Application for a non-material amendment following a grant of planning permission.

EP/27/10/NMA

DEMOLITION OF EXISTING BUILDINGS AND ERECT 21 NO. NEW DWELLINGS, ACCESS, PARKING & PROVISION OF PUBLIC OPEN SPACE AT FORMER REDUNDANT NURSERY SITE.

EP/95/08

drawing no  
5326/L(04)003

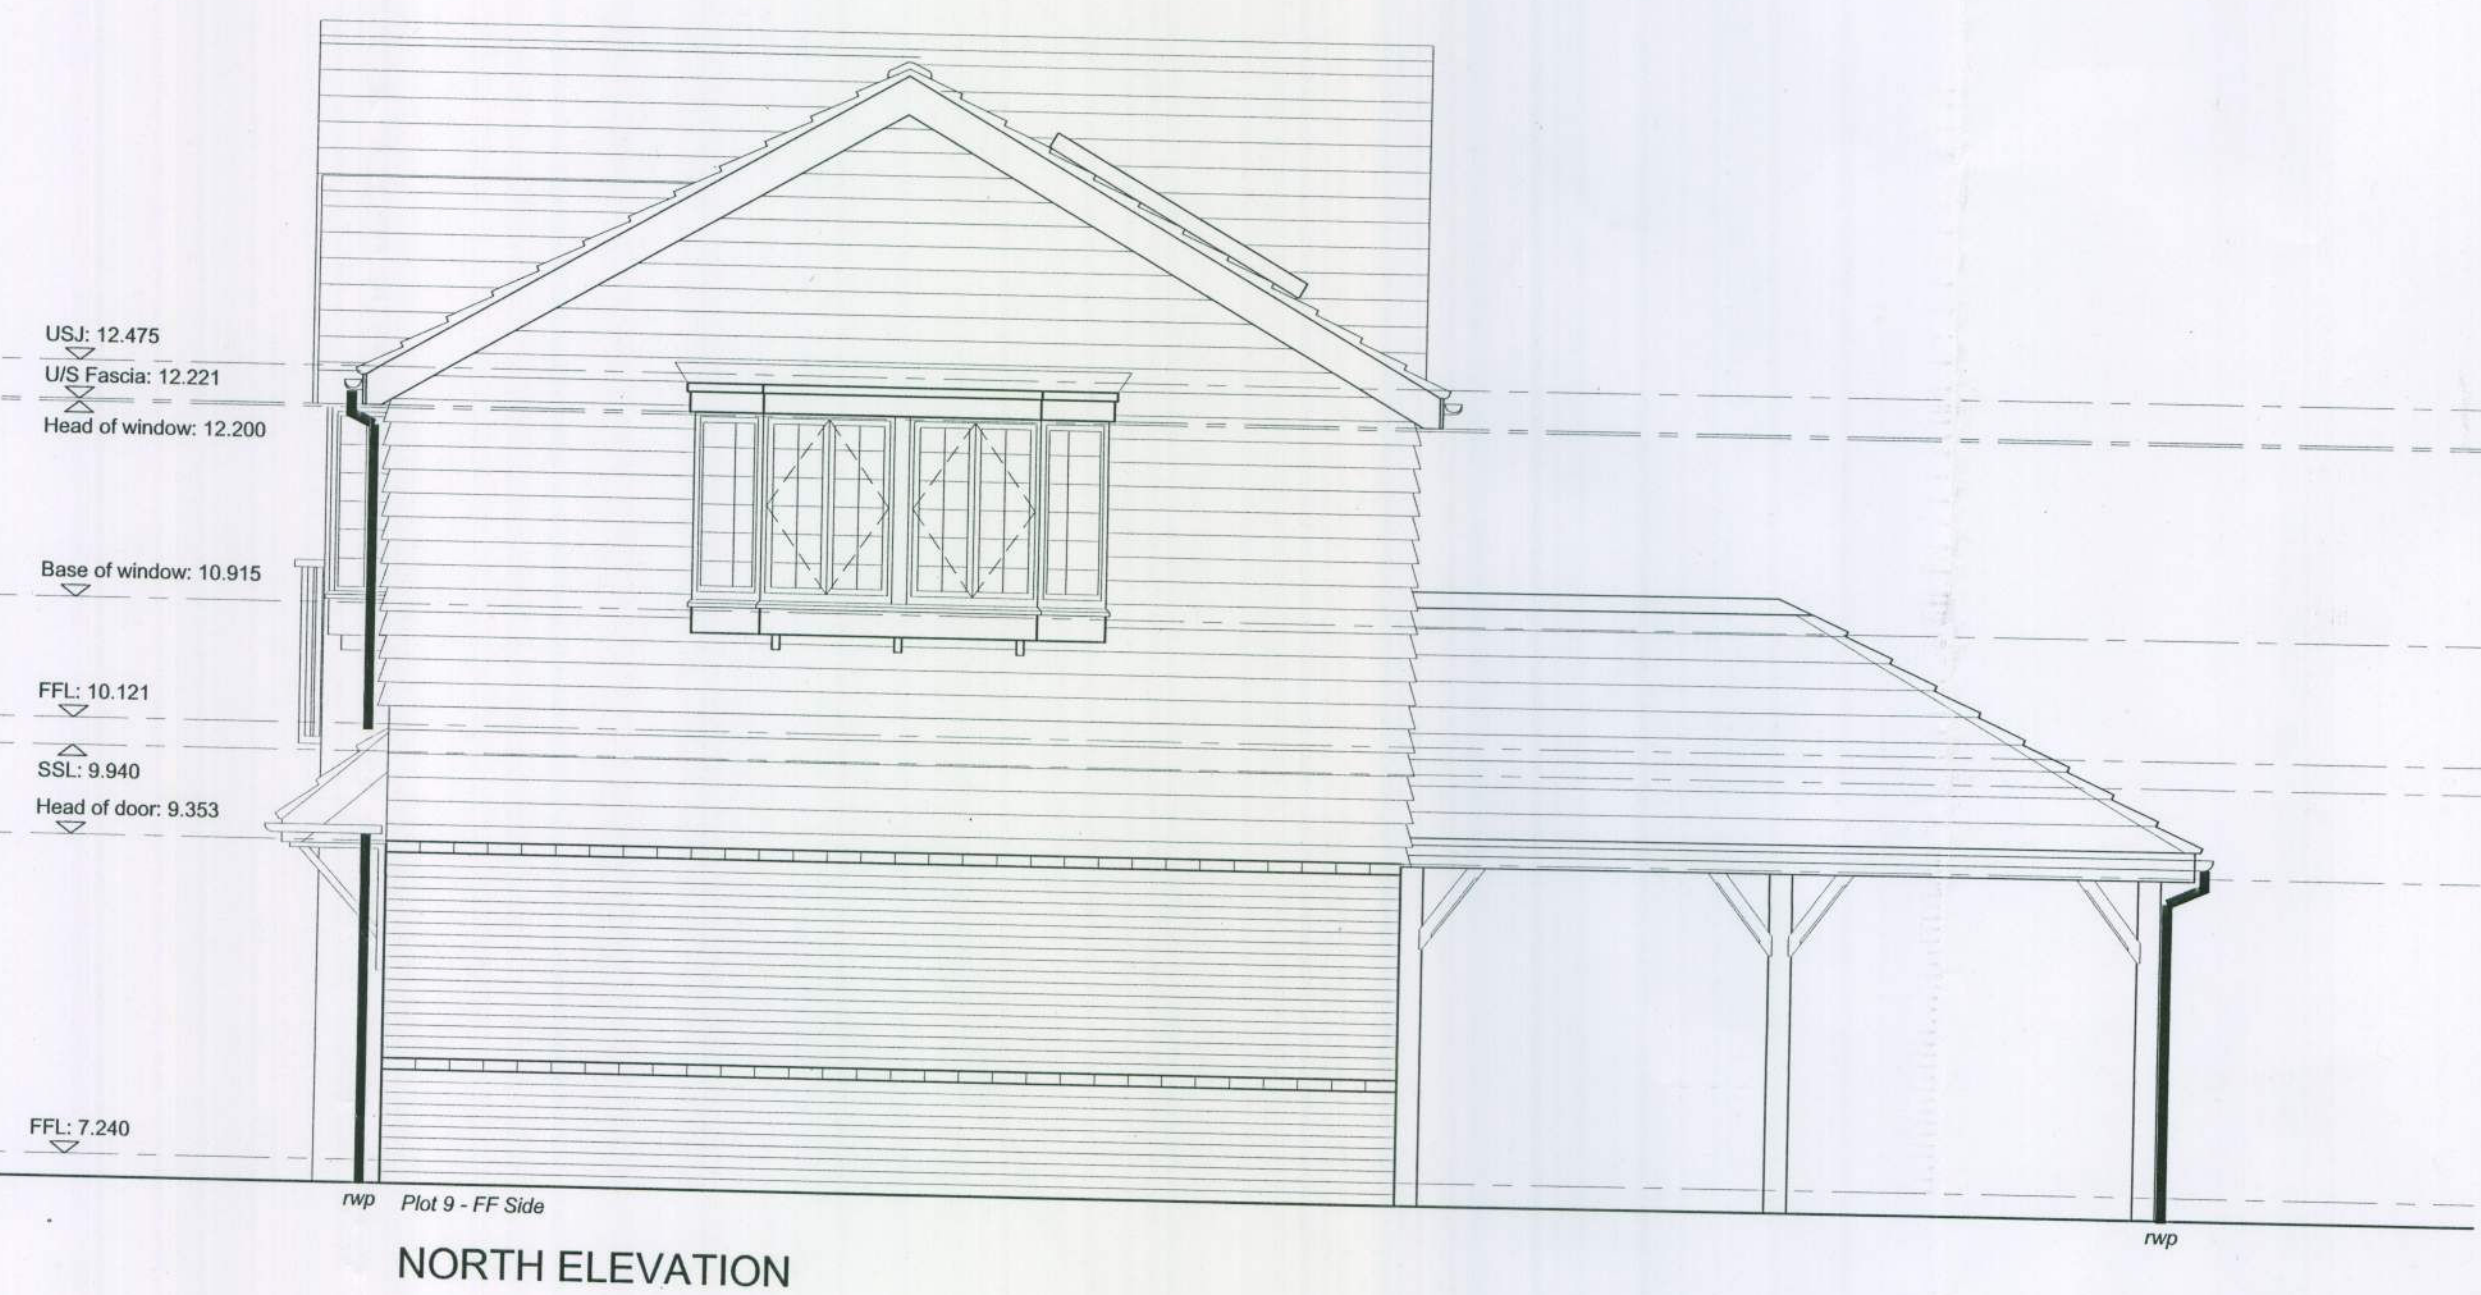
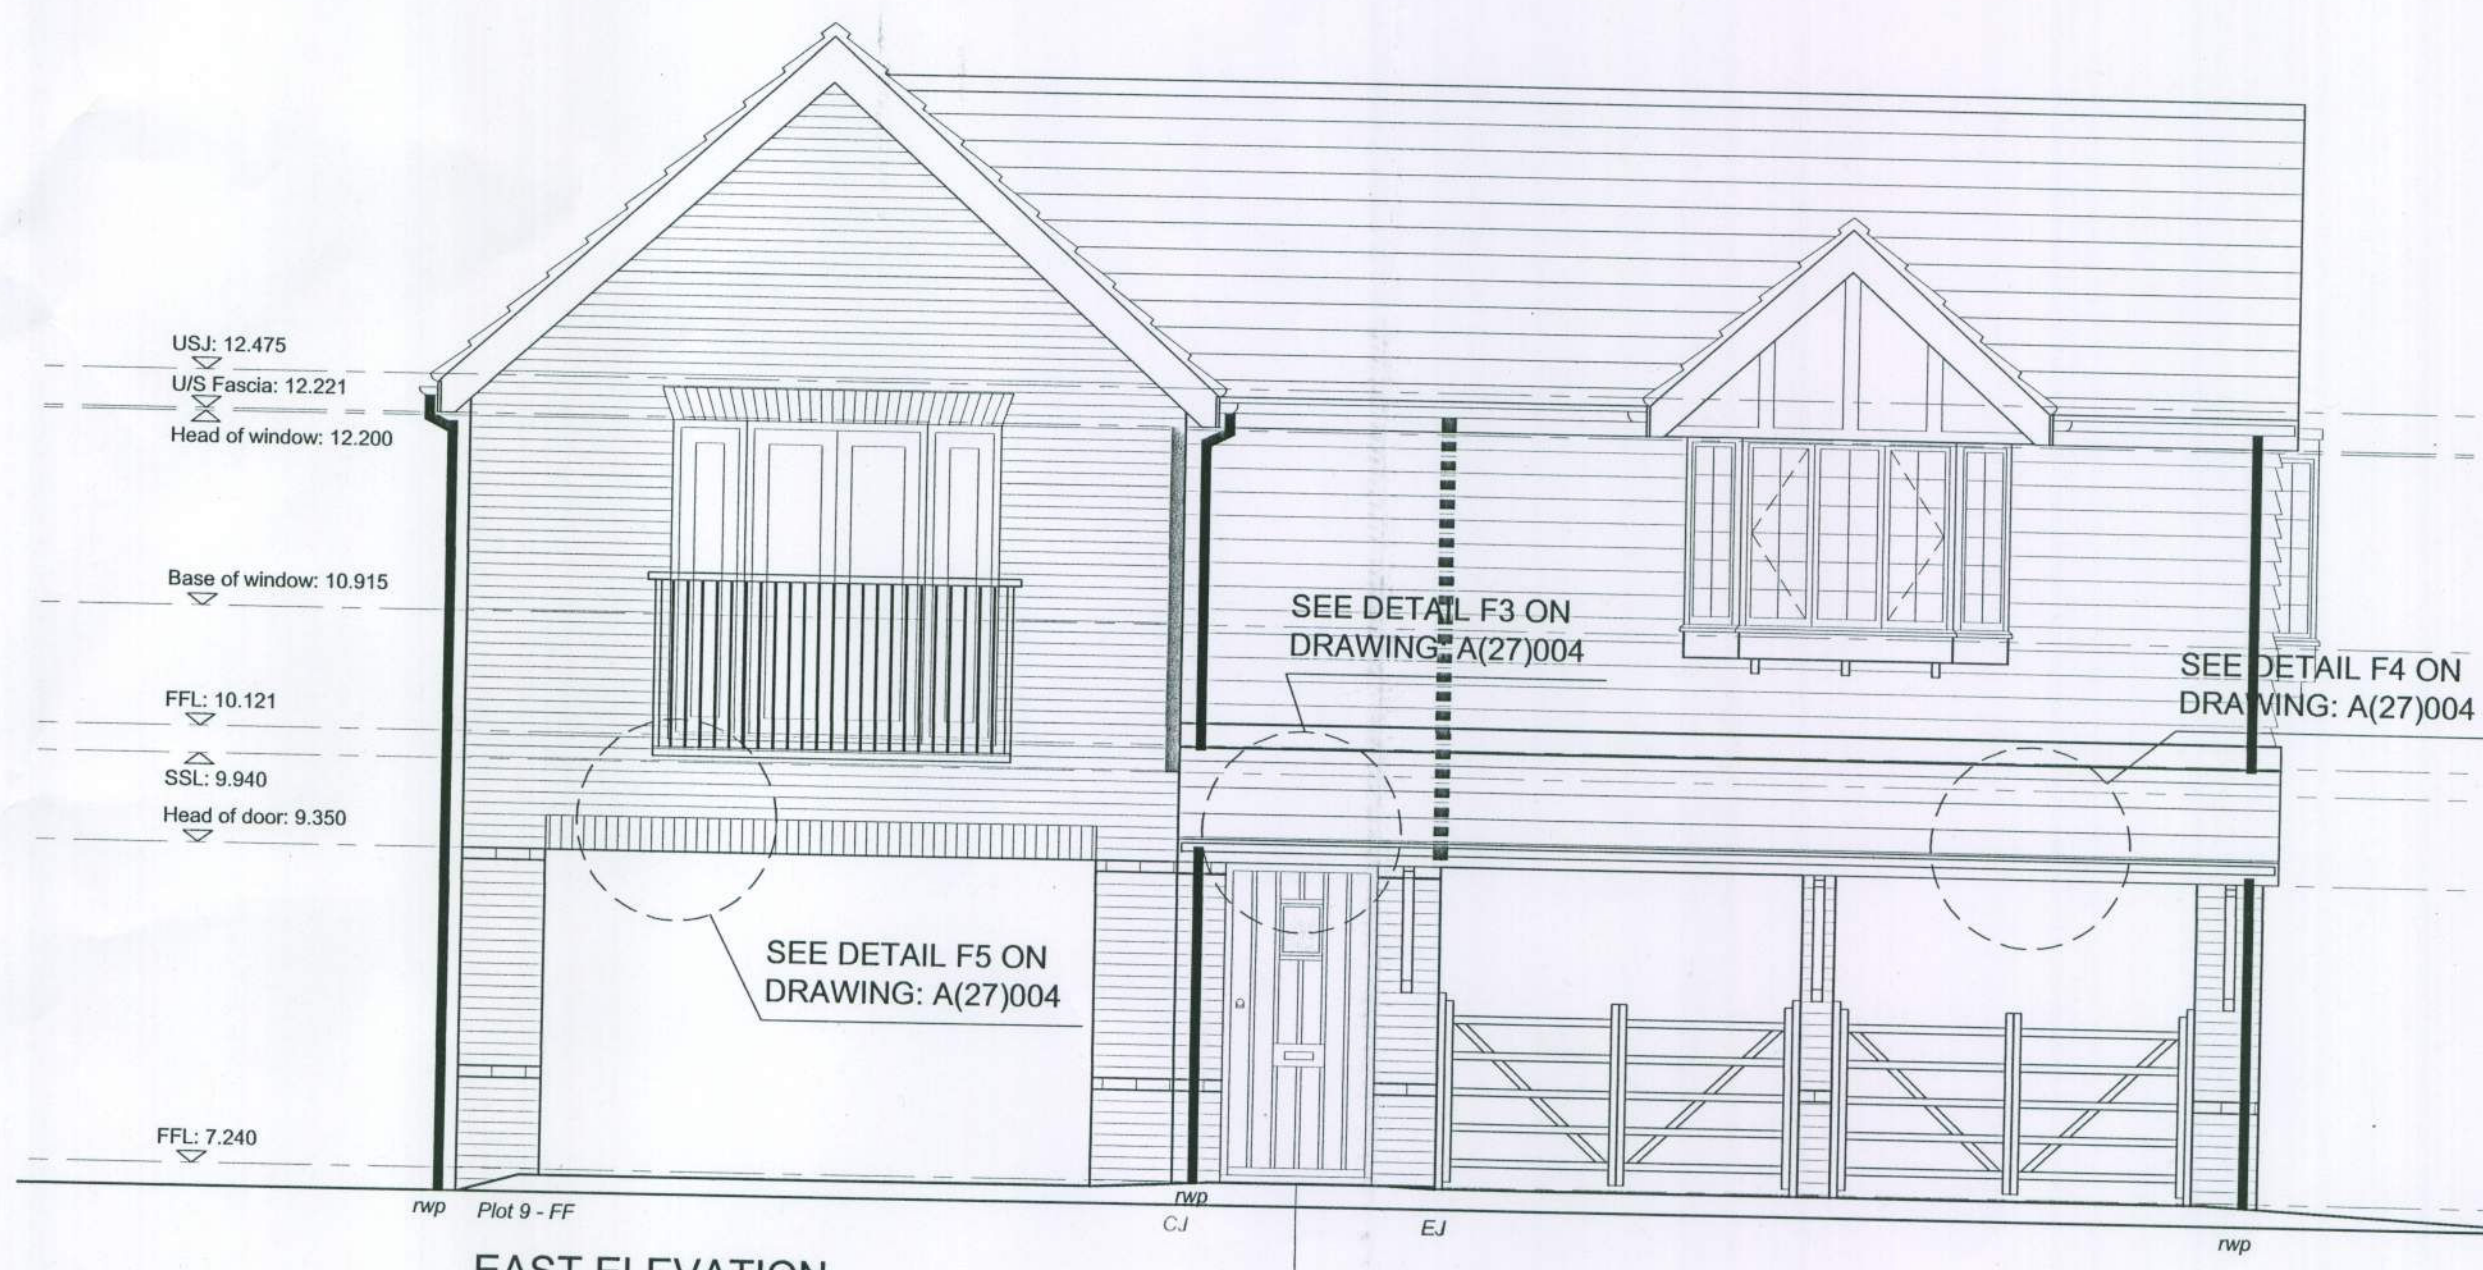
1. TO OMIT THE GALLOWS BRACKETS SHOWN ON THE EAST ELEVATION AT FIRST FLOOR BOTH SIDES OF THE GABLE WINDOW
2. TO REVISE THE CHIMNEY DESIGN FROM THOSE SHOWN ON THE APPROVED DRAWINGS TO THOSE INDICATED ON OUR PROPOSED CONSTRUCTION DRAWINGS.

1. THE GALLOWS BRACKETS ARE CURRENTLY DETAILED AS BACKING ONTO TILE HANGING, IT WILL BE VERY DIFFICULT TO INSTALL THESE GALLOWS BRACKET WITH TILE HANGING FINISHING NEATLY INTO BOTH SIDES OF THE BRACKET.
2. WE WISH TO VARY THE DESIGN OF THE CHIMNEYS ON THE APPROVED PLANNING DRAWING & INSTEAD CONSTRUCT THE CHIMNEYS AS DETAILED ON OUR CONSTRUCTION DRAWING.
